Attachment A

FIGURE 3.12

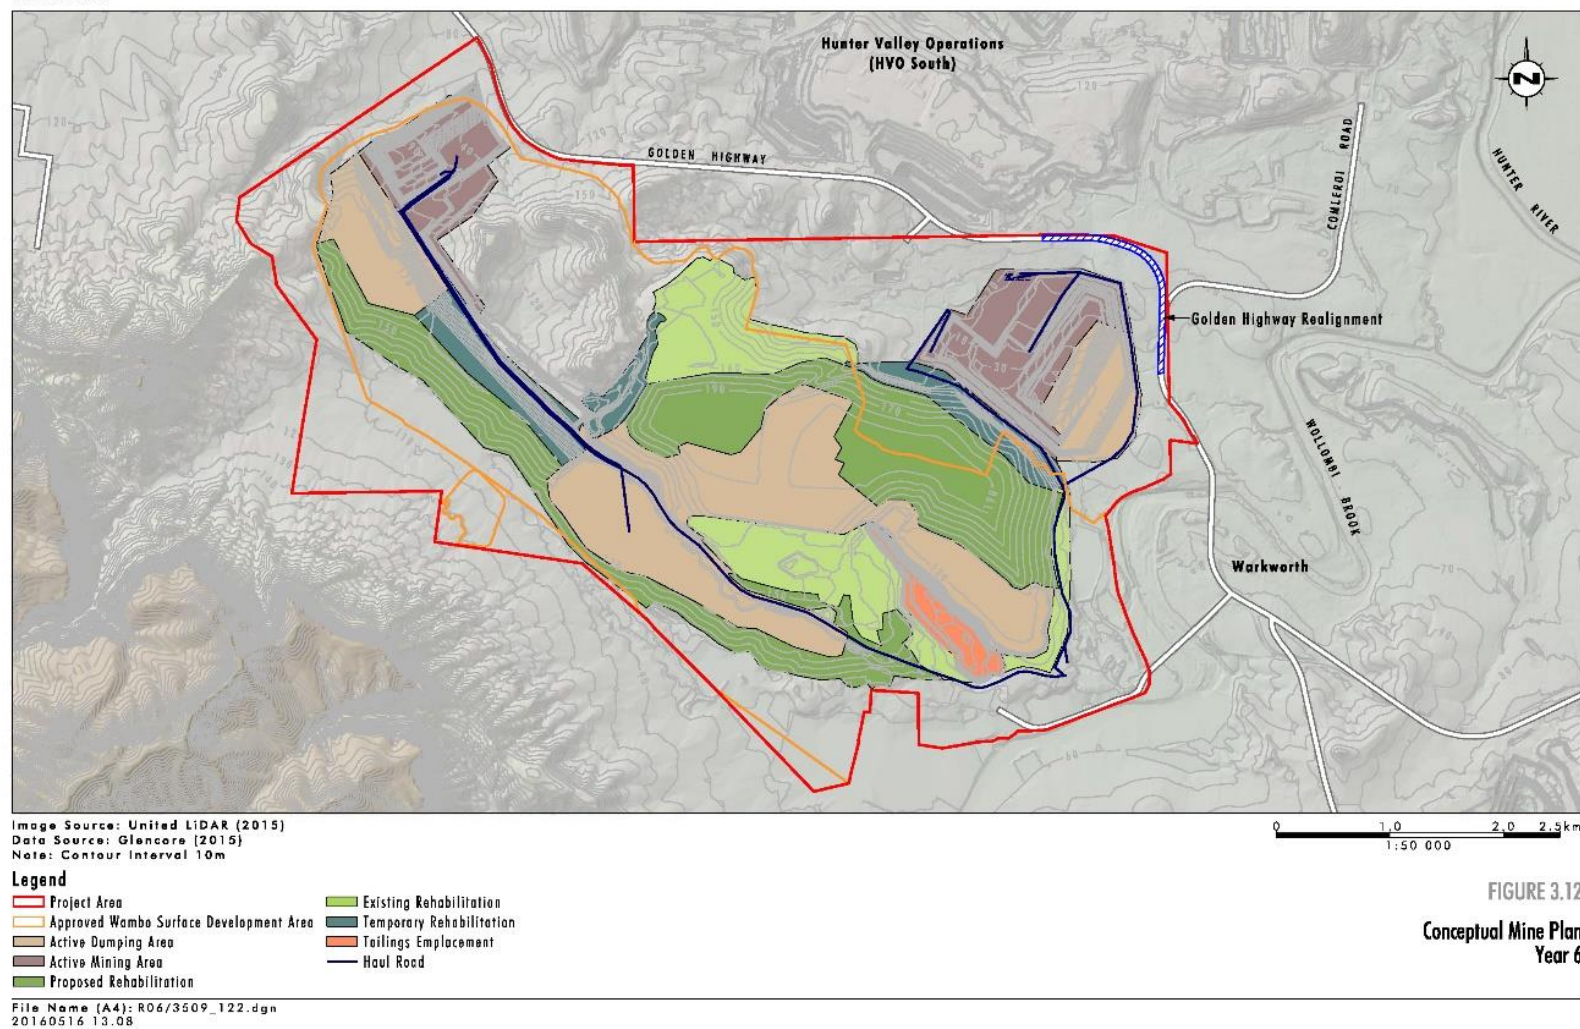
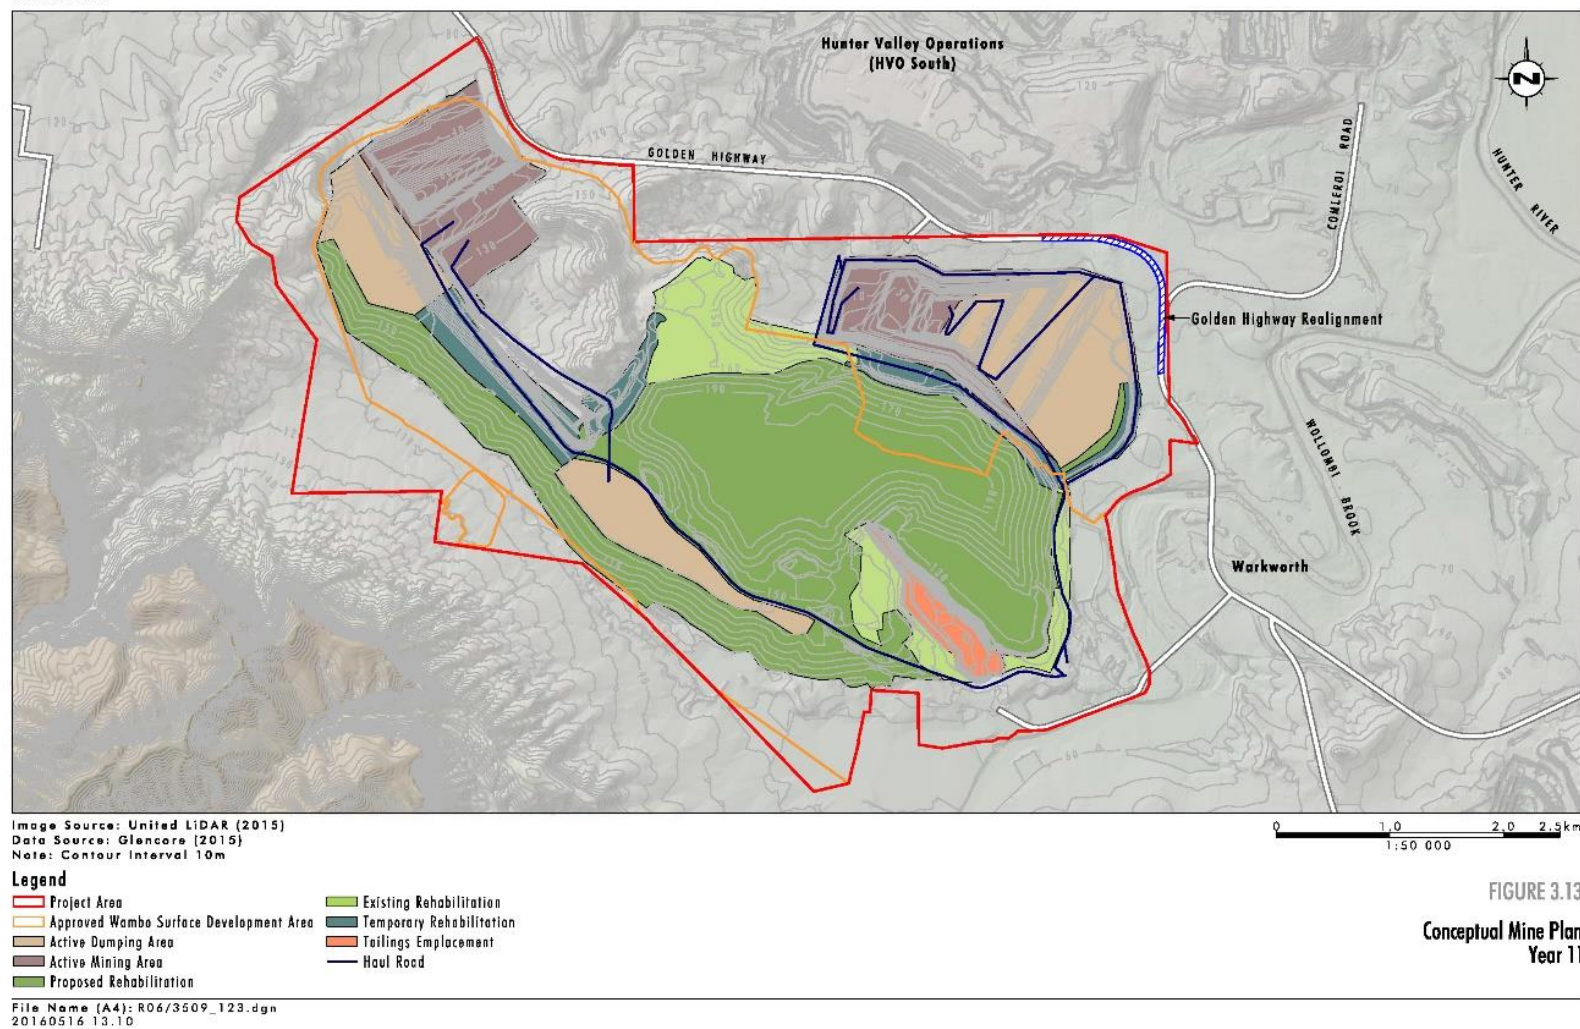
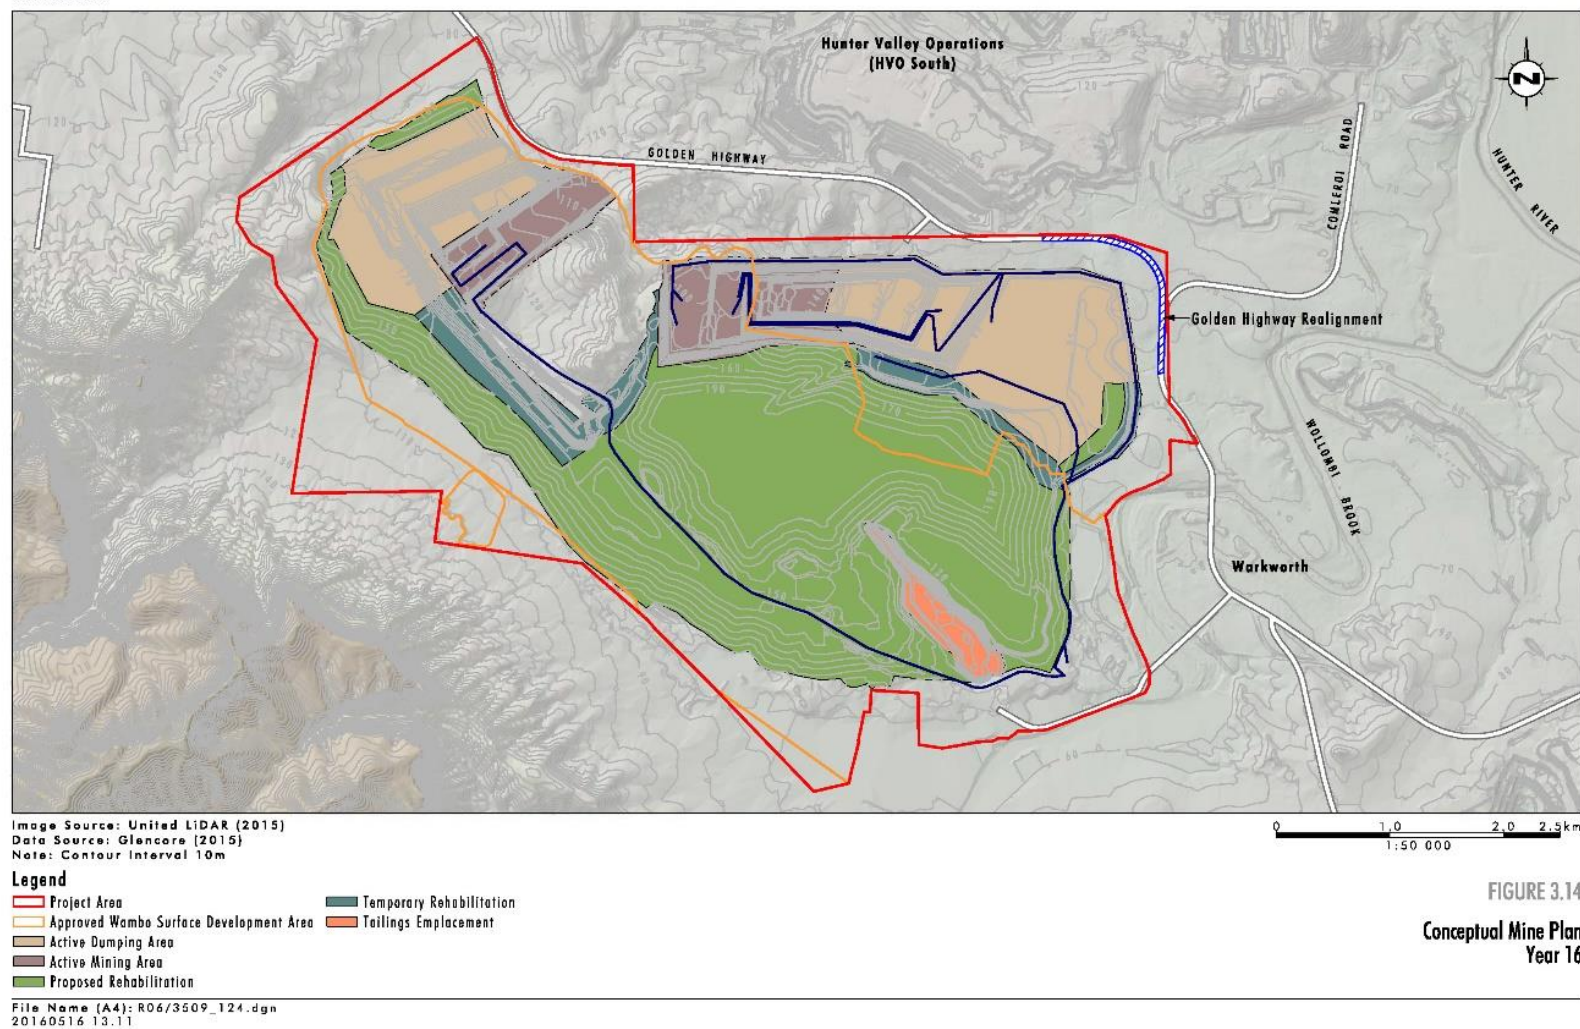
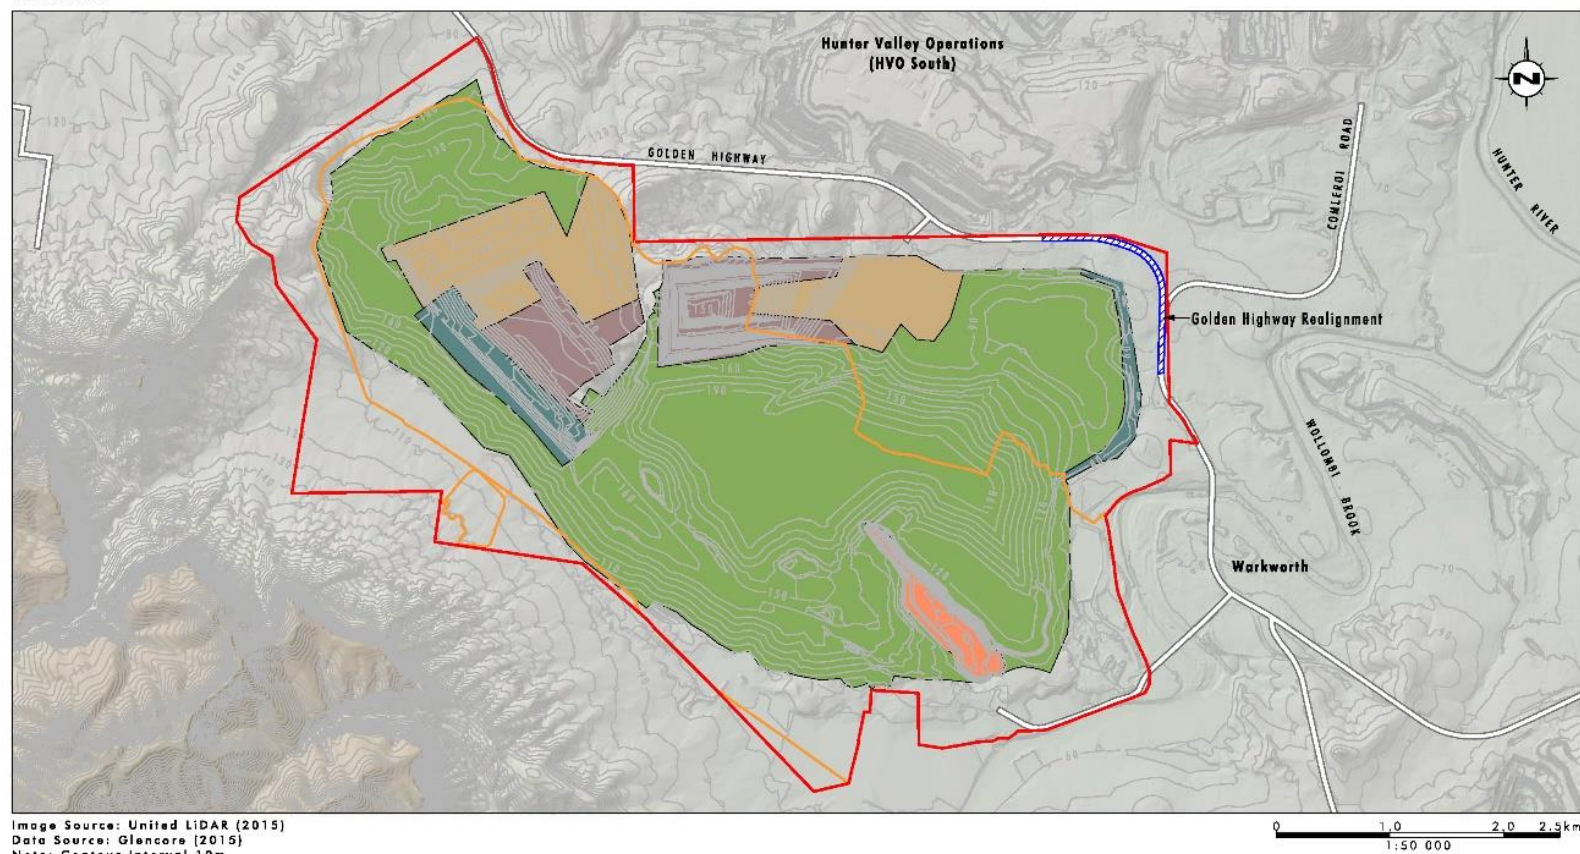
- a. The conceptual mine plans in the Main EIS (Figures 3.11 to 3.16) show the areal extent of rehabilitation across the project. However the area proposed for disturbance is shown to be greater in Figure 1.11 of the Statement of Commitments. Clarify the extent and type of disturbance in the RTS.
